An
Bord
Pleanála

ABP-312606-22

Re: Recommendation to request further information for s.37E application ABP-312606-22

An application has been made by Ballinagree Wind DAC under the provisions of section 37E of the Planning and Development Act 2000, as amended, for the development of a wind farm development of 20 turbines with 110kV electrical substation and all related site works and ancillary development in the townlands of Annagannihy, Aughinida, Ballynagree East, Ballynagree West, Bawnmore, Caherbaroul, Carrigagulla, Carrigduff, Clonavrick, Derryroe, Drishane More, Dromagh, Drominahilla, Dromskehy and other townlands, Co. Cork.

- Notes.**
- This drawing is for planning purposes only.
 - Dimensions in meters unless otherwise noted.
 - Levels shown relative to ordnance datum (Mal)
 - Co-ordinates are to Irish Transverse Mercator
 - Extent of earthworks not shown.

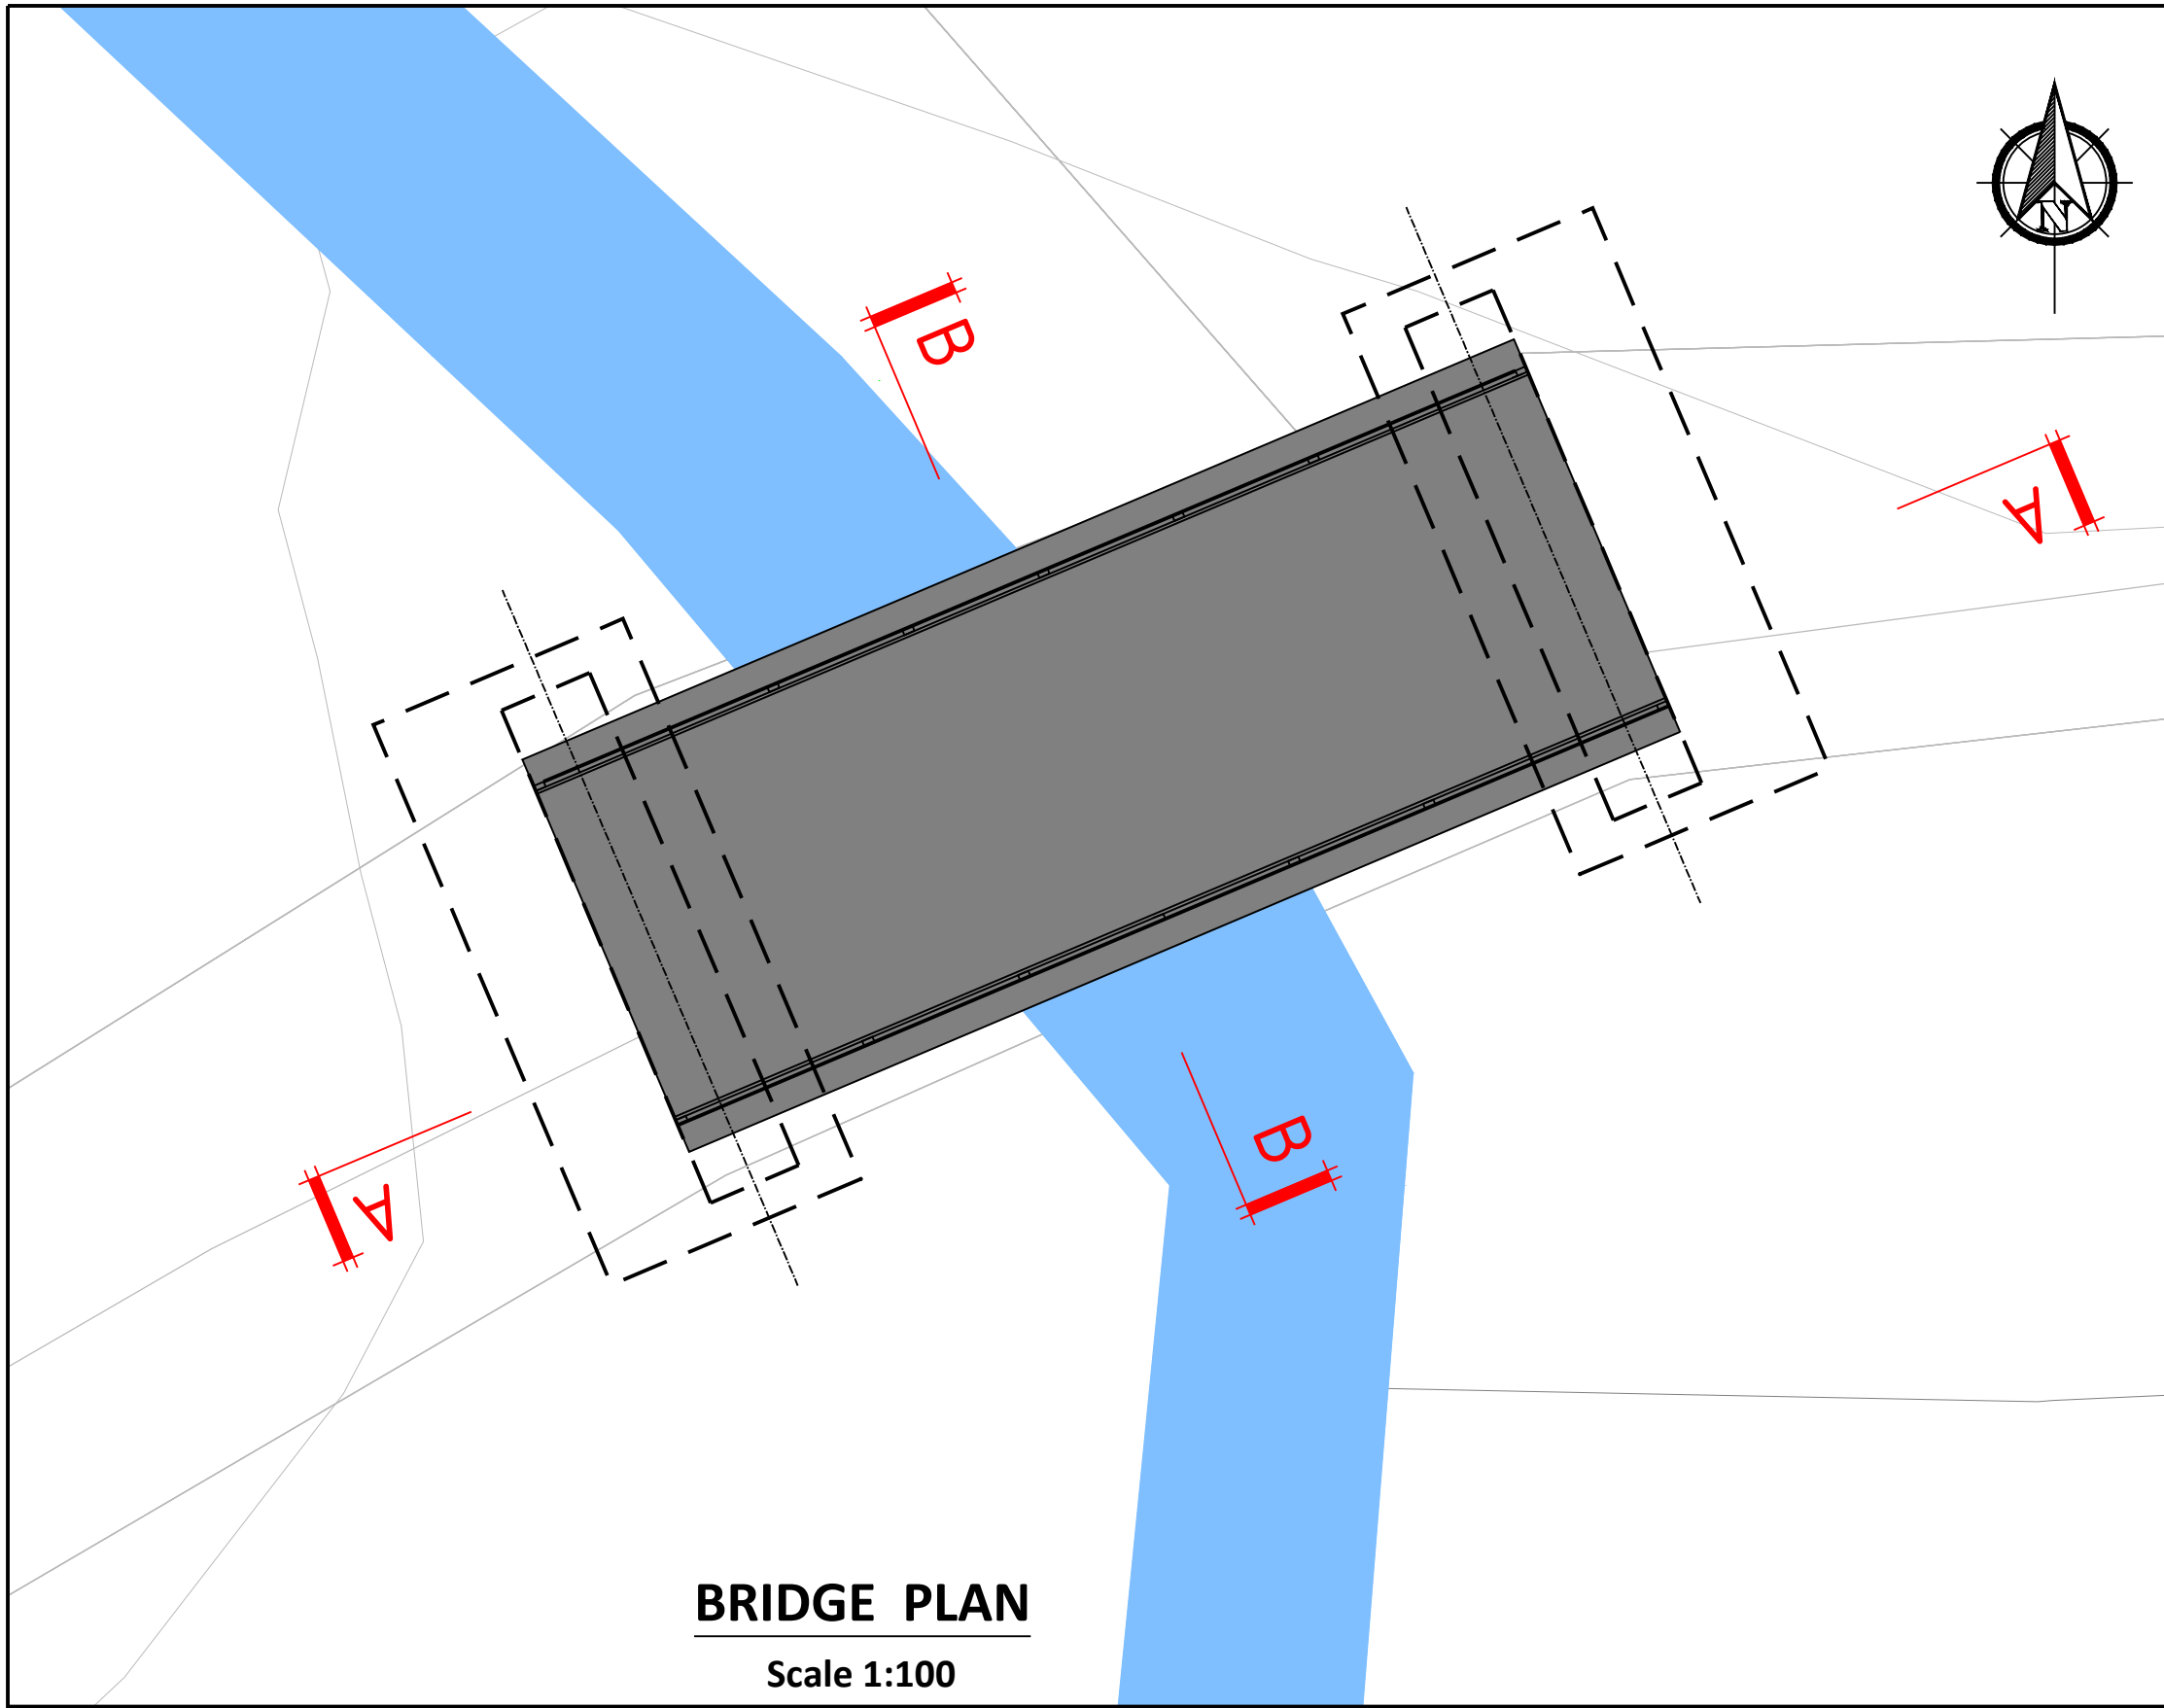
- WF-HF8: This structure appears to be located at a bend in the watercourse. The structure and bank should be designed to be safe against scour and erosion. This applies to all crossings for which section 50 consent is required.

- (d) Confirm whether the design of watercourse crossings WF-HF5 and WF-HF8 complies with OPW requirements.
- (iv) You are requested to provide a detailed response to the matters raised in the submission made by Cork County Council. In particular, this should include a response to the list of items contained in Appendix B of said submission.
